[REDACTED]
Cc: Michael Eastham <Michael.Eastham@arun.gov.uk>; Jamie Brown [REDACTED]
Bernadette Gledhill [REDACTED]
Subject: FW: Lyminster Bypass: CEMP

Further to Arun's comments below is what WSCC as Highway Authority wish to comment upon:

Please could you ensure that the CEMP refers to Lyminster Bypass (**southern section**) and Fitzalan Link Road (**northern section**) throughout the document.

Appendix C: Phase 1 Site Compound and Access

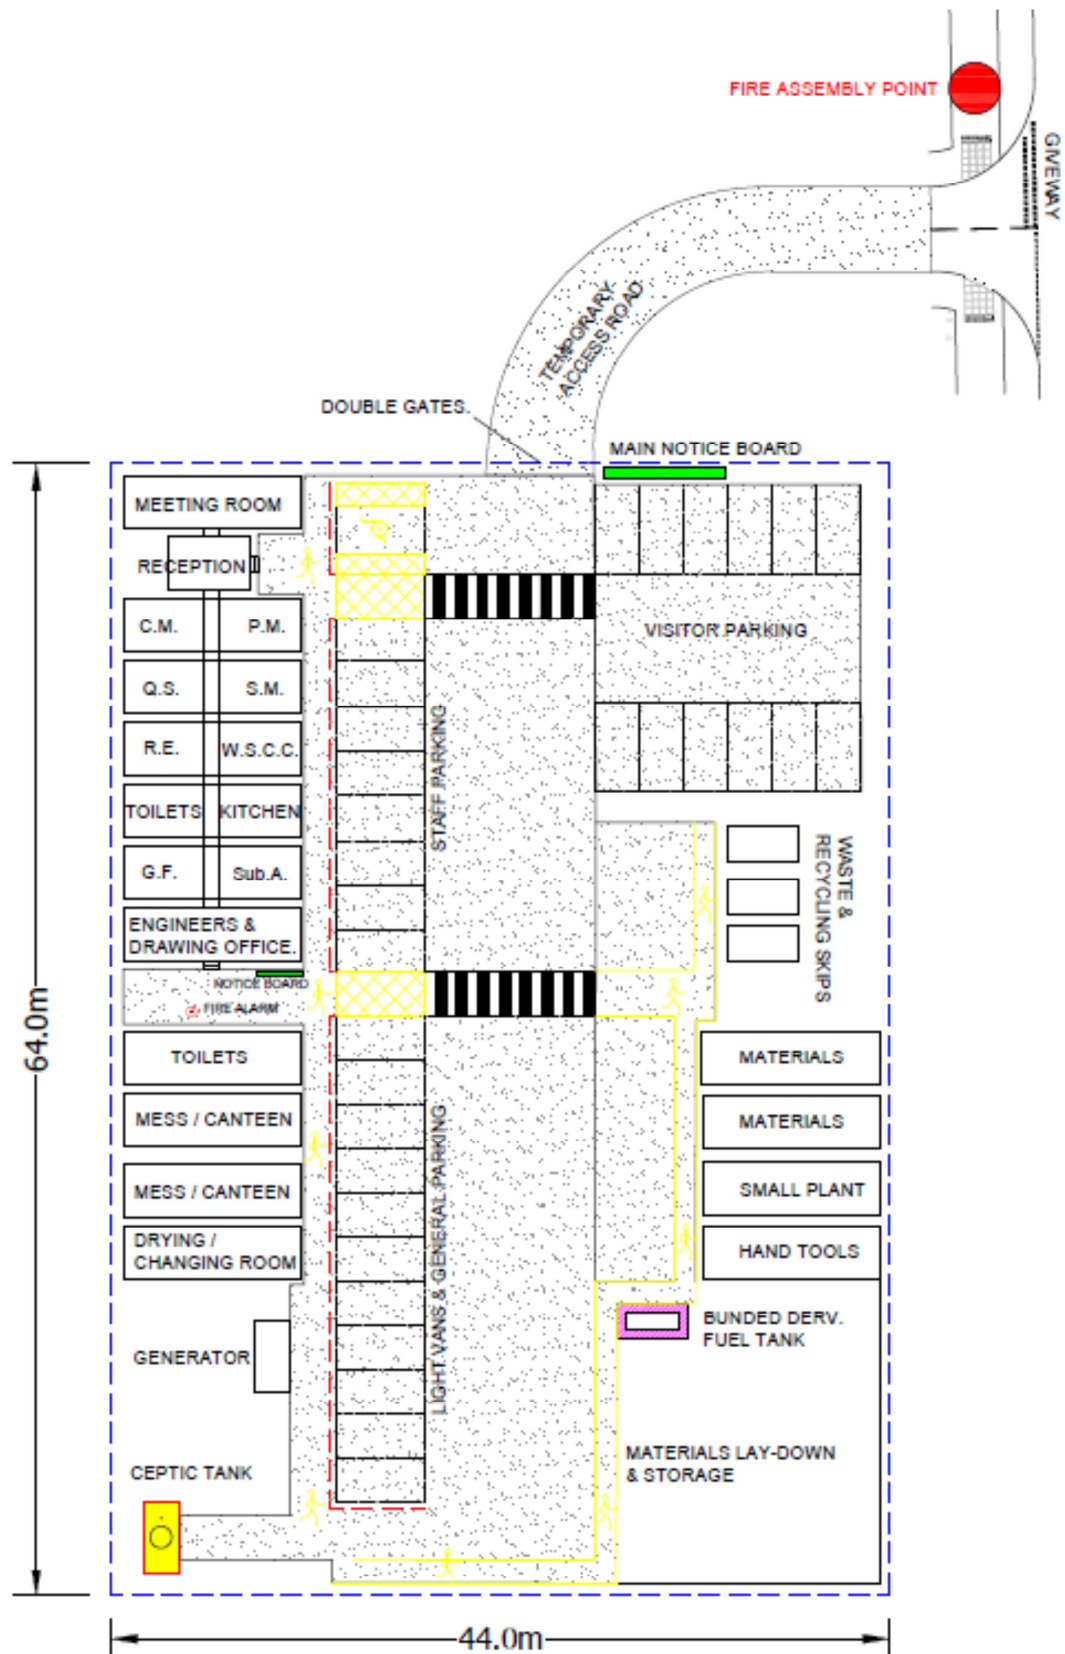
- Parking areas have not been demonstrated i.e not shown or laid out therefore difficult to know how much contractor parking could be housed. Clarification on the level of parking and its design and layout should be provided.

Appendix A: Location Map

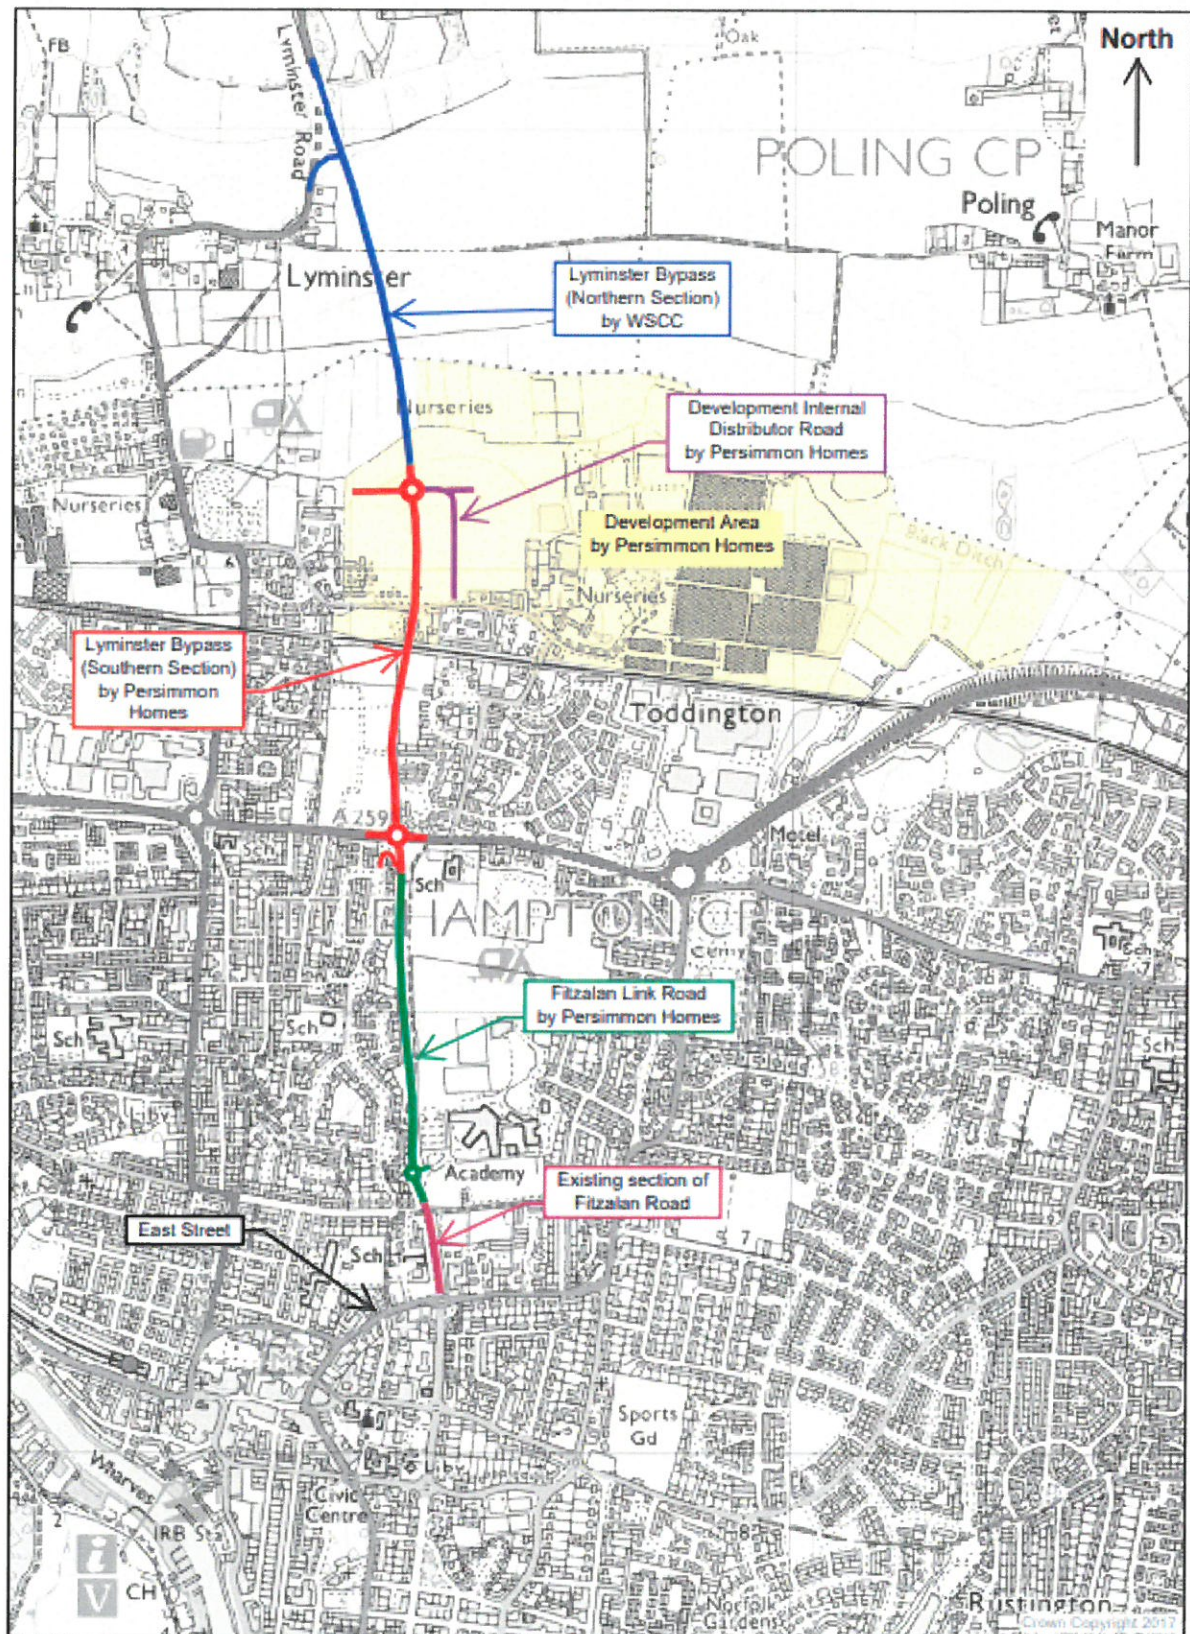
The Appendix A Location Plan needs to include the southern section of the Lyminster Bypass from Hampton Park to the A259.
